From: Martyn White
Sent: 26 May 2022 18:12:24
To: Harry Chalk
Cc:
Subject: LU/93/22/PL

LU/93/22/PL

Replacement of 43 No. existing timber windows with new double glazed PVCu windows.

Nightingale Nursing Home 43 Beach Road Littlehampton BN17 5JG

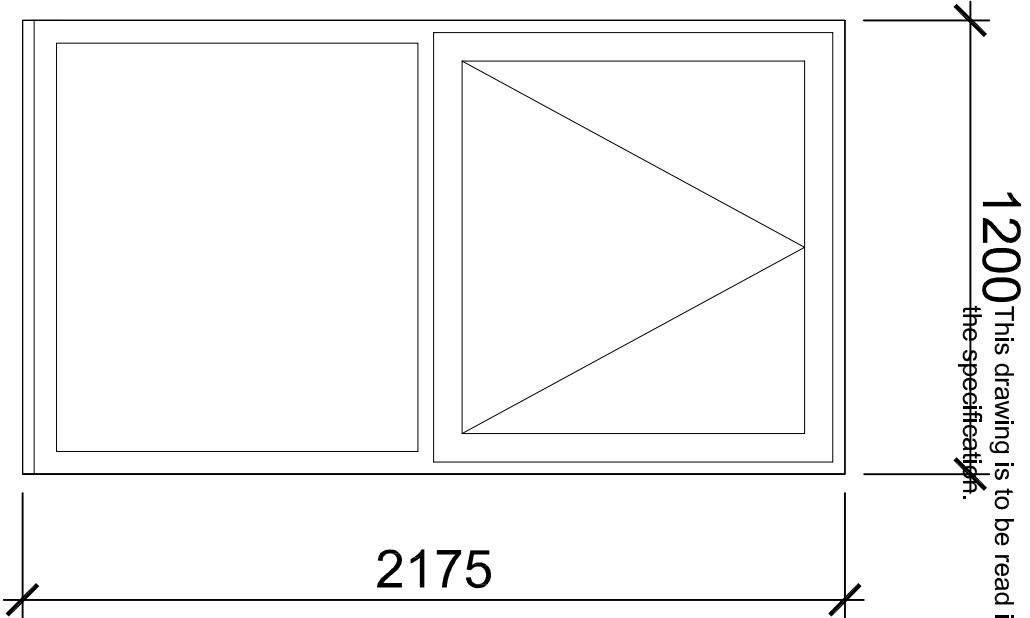
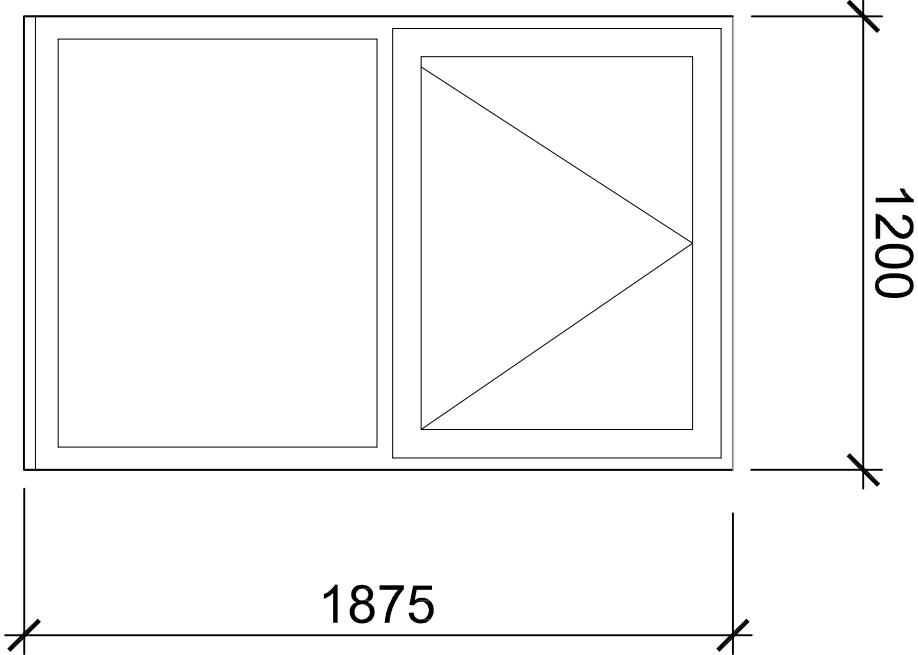
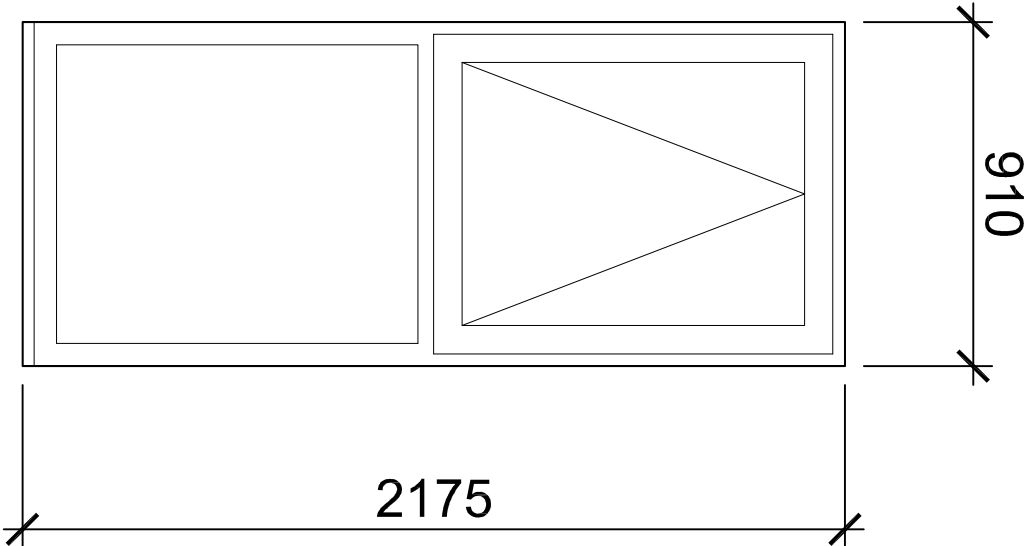
Imitation sash windows, such as those proposed here, which consist of top-hung hinged sections, are also unacceptable, as they do not properly reflect the traditional design of the windows already present in the building, especially the older part.

The proposed design and materials of the proposed replacement windows are not appropriate for the building and will detract from the character of the area. Whilst it is acknowledged that a number of other buildings have already replaced some or all of their windows with UPVC ones, it is suggested that there is the opportunity to retain an important feature within this building.
